Title: Stage 1 Road Safety Audit
For;
Phase 2 Residential Development (SHD), R125
Dunshaughlin Co. Meath.

Client: Waterman Moylan

Report reference: 0848R01

TITLE **ROAD LAYOUT SHEET 2 OF 3**

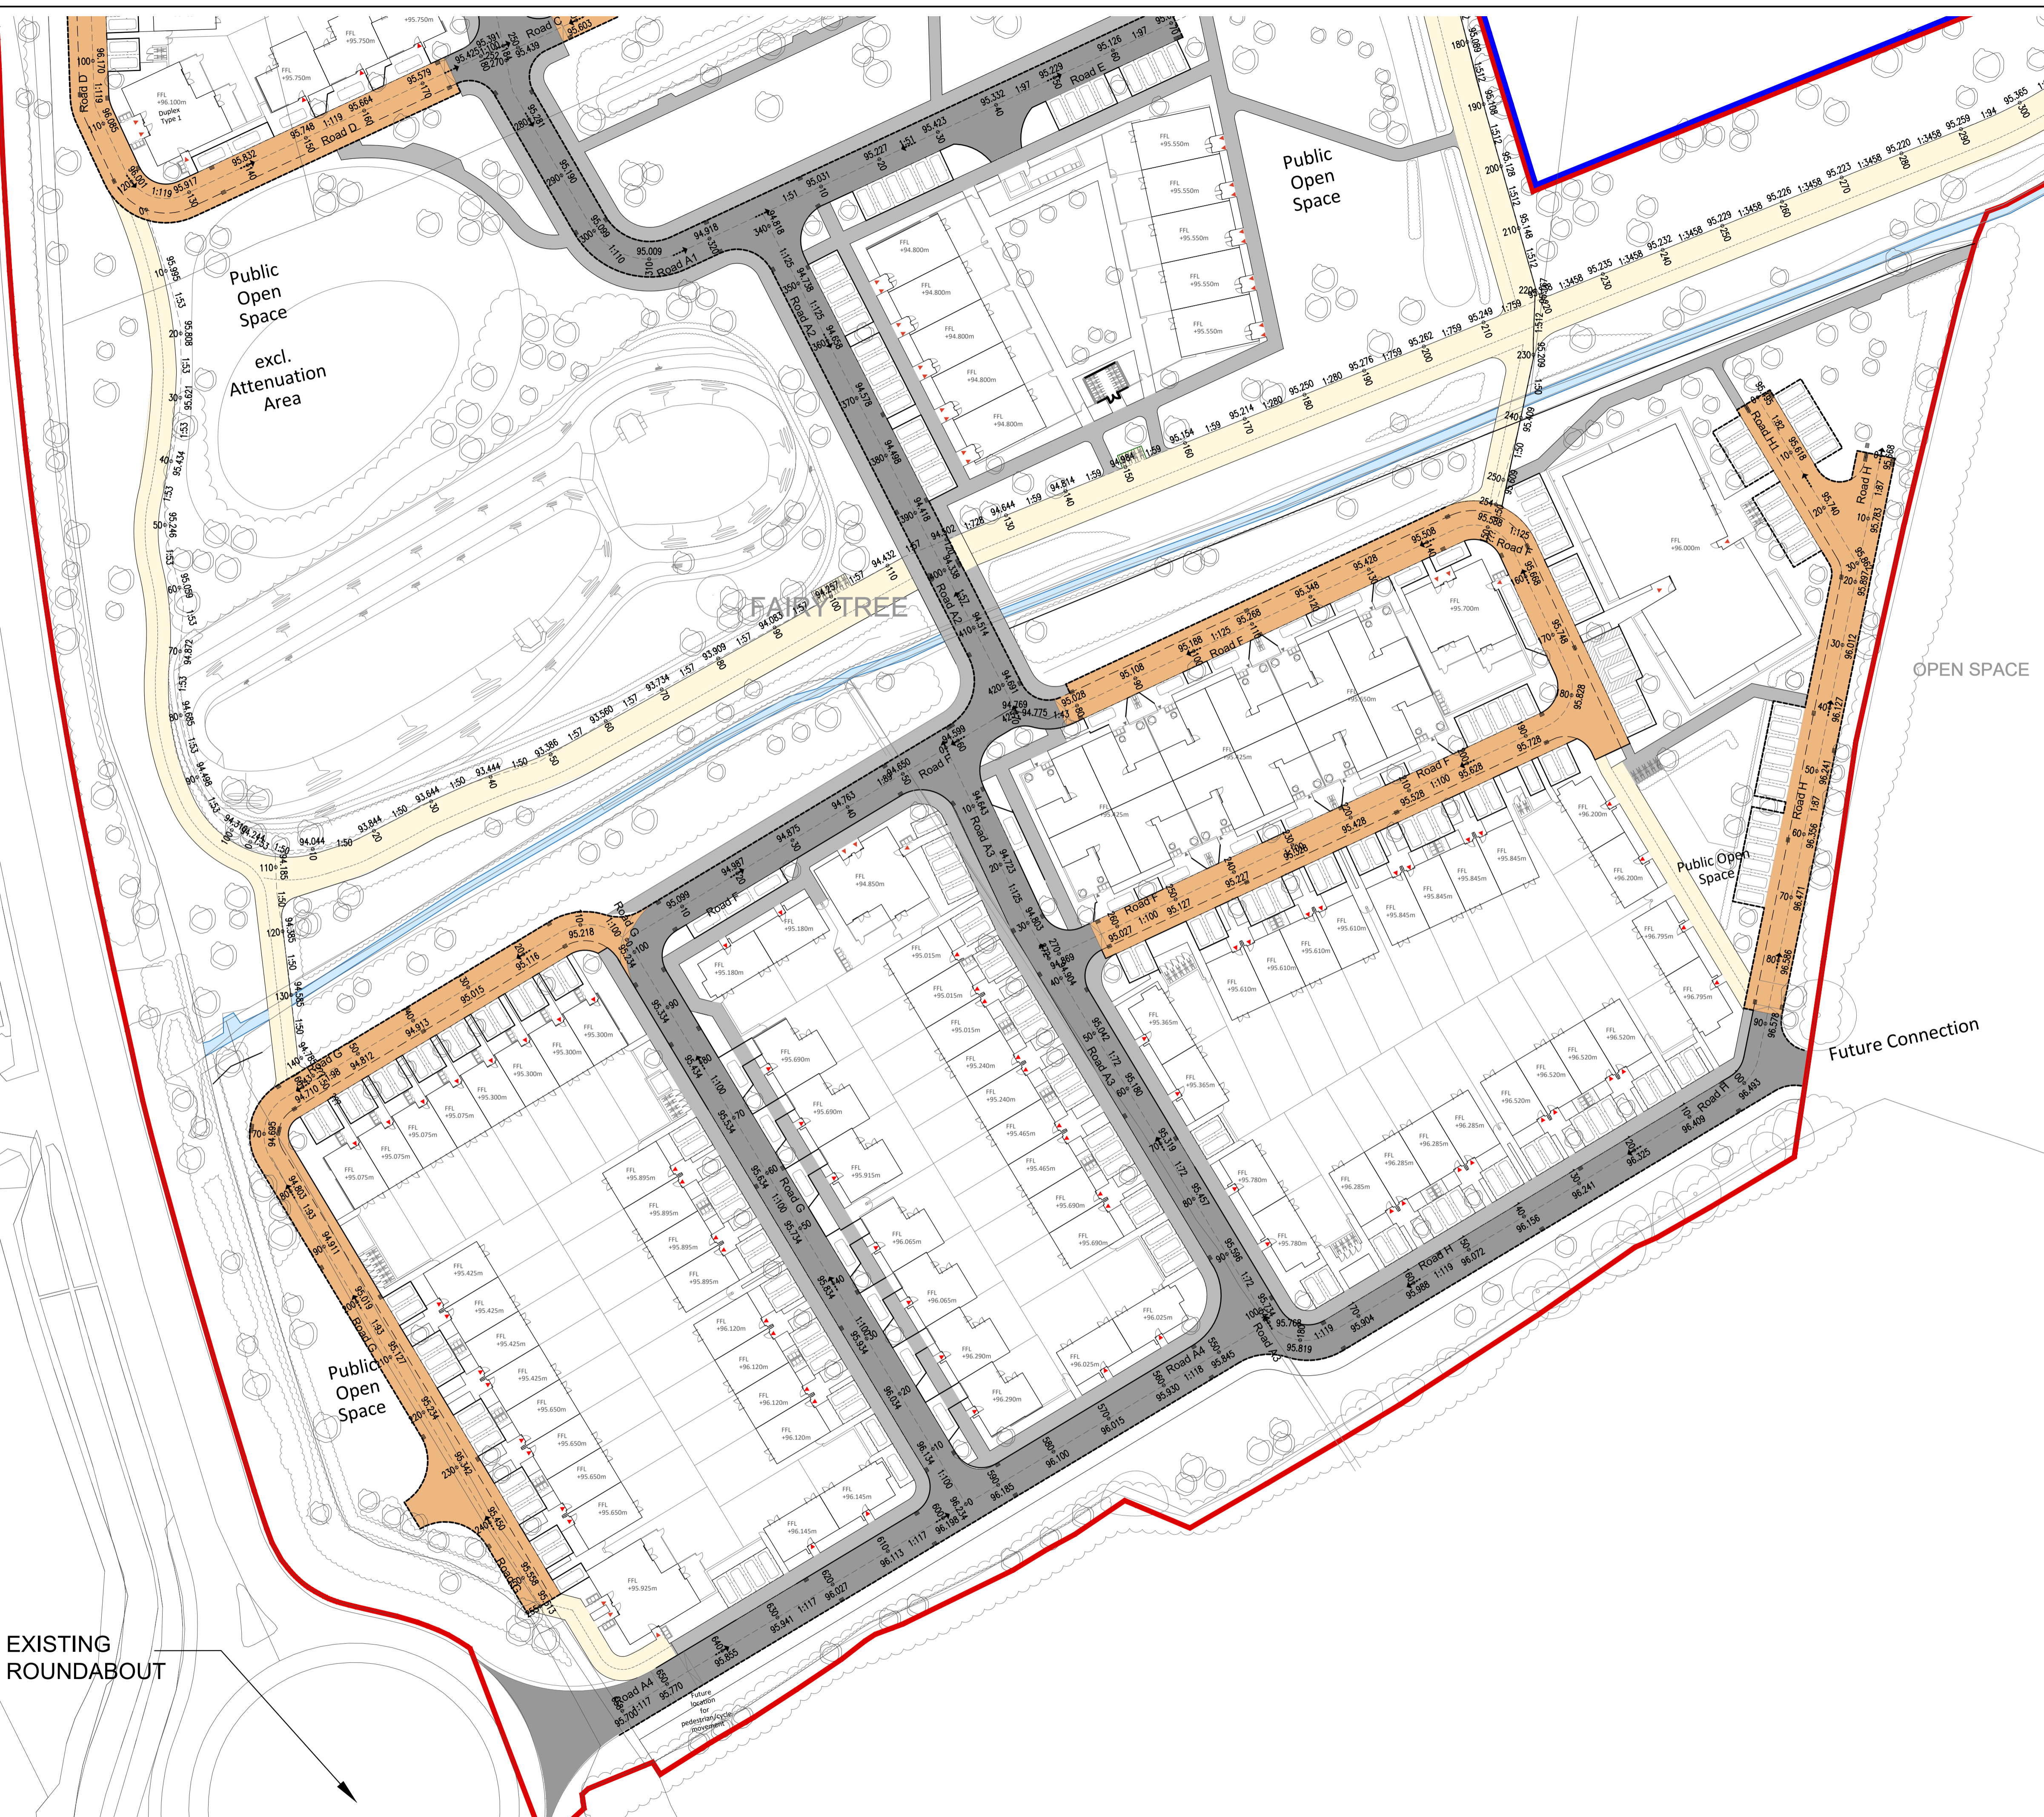
There is an existing safety barrier on the eastern verge of the R125 on approach to the roundabout at headwalls and open drains. It is unclear if a risk assessment has been carried out for the future need of this safety barrier. Without a safety barrier an errant vehicle could collide with a headwall/open drain and lead to injuries for the vehicle occupants.

It is recommended that a risk assessment be carried out, taking into account the proposed Phase 1 roundabout on the R125 and, if a barrier is required, then the area behind the barrier (working width) should be kept clear of any vegetation other than grass which can be easily maintained.

Paragraph No. in Quality Audit Report	Problem accepted (yes/no)	Recommended measure accepted (yes/no)	Alternative measures (describe)	Alternative measures accepted by Auditors (Yes/No)
3.1	Yes	Yes		
3.2	Yes	Yes	The R125 is controlled by MCC /A risk assessment will be undertaken at detailed design Stage. These drawings need to be submitted to MCC for final approval which will address any alterations to the existing safety barrier to facilitate the new access point before works are undertaken and will be reassessed as part of the Stage 2 RSA process	Yes
